Re: Project PR 2019-002184, 4909 Juan Tabo Blvd. NE

Consensus Planning has submitted an Application re: Project PR 2019-002184 to the Development Review Board for a Site Plan-DRB for the property located at 4909 Juan Tabo Boulevard NE on behalf of Guardian Storage and the property owner SL Juan Tabo Land, LLC. The site plan calls for an Indoor Storage Building to be constructed on this 2.37 acre area. The site plan review for this property is scheduled for the December 18, 2019 DRB meeting.

Concerns about the Applicant's Analysis of Sensitive Lands Study:

Exhibit A, Sensitive Lands

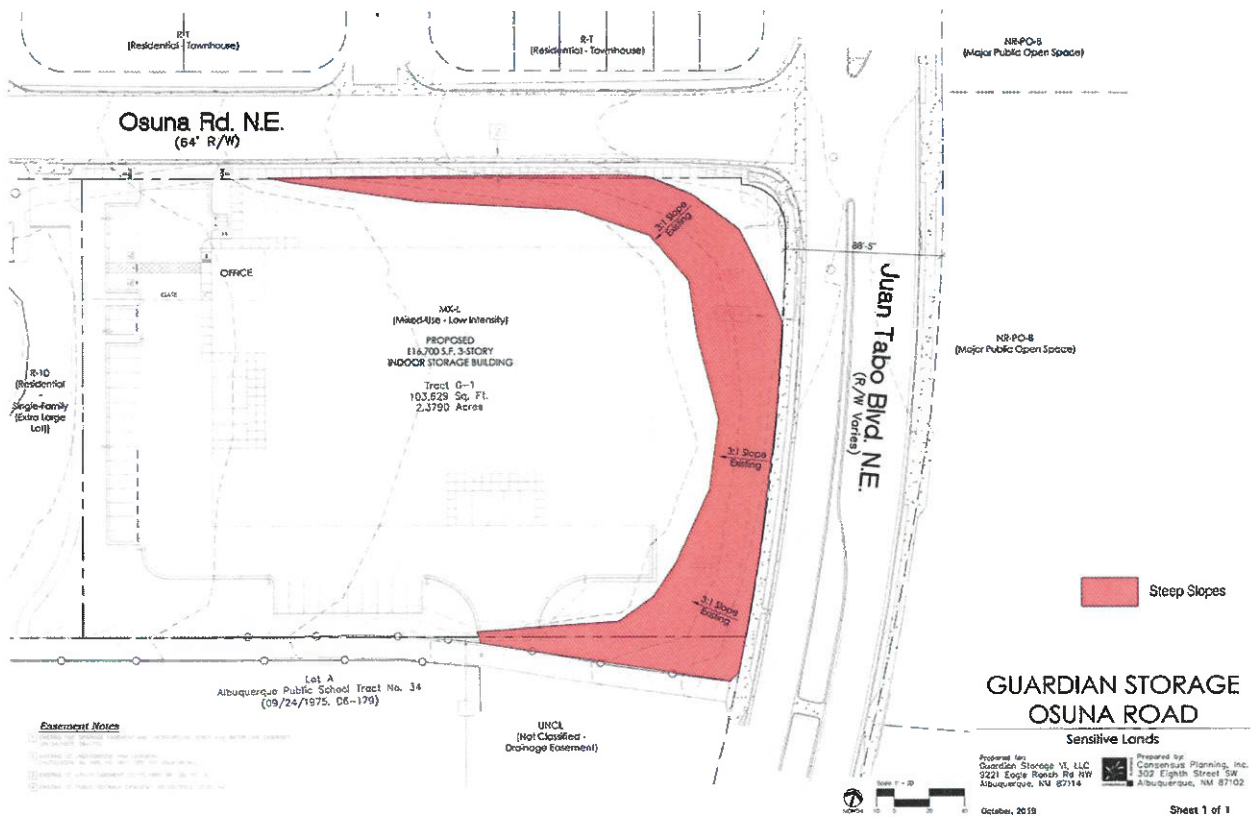
It should be noted that the Consensus Planning's Application contains a Sensitive Lands Analysis which was conducted by a Landscape architect, Scott Culler employed by Consensus Planning. This Sensitive Lands Analysis is flawed in two respects: a) the Analysis was not conducted by a registered Civil Engineer with direct experience in sensitive lands analysis – but by a landscape architect that is unqualified to undertake such a detailed analysis; and b) the Analysis was not conducted by an independent and impartial professional, but an employee of the Applicant.

Additionally the submitted Sensitive Lands Analysis states that "the only types of sensitive lands present on the site are steep slopes". This is a flawed analysis in that the subject property site, in addition to containing steep slopes, is also: *in a corridor* (Bear Canyon Arroyo RMP and Design Overlay Zone); *next to a trail* (Bear Canyon Multipurpose trail); *next to diversion channel* (AMAFCA stormwater diversion channel to the South); *in view sheds* (view shed extends from the Sandia Mts. West to the Rio Grande) and *in flood plains* (FEMA designated 100 year flood plain).

I might suggest that a new Sensitive Lands Analysis be requested by City Staff that is completed by an independent, qualified professional who is not employed by the Applicant.
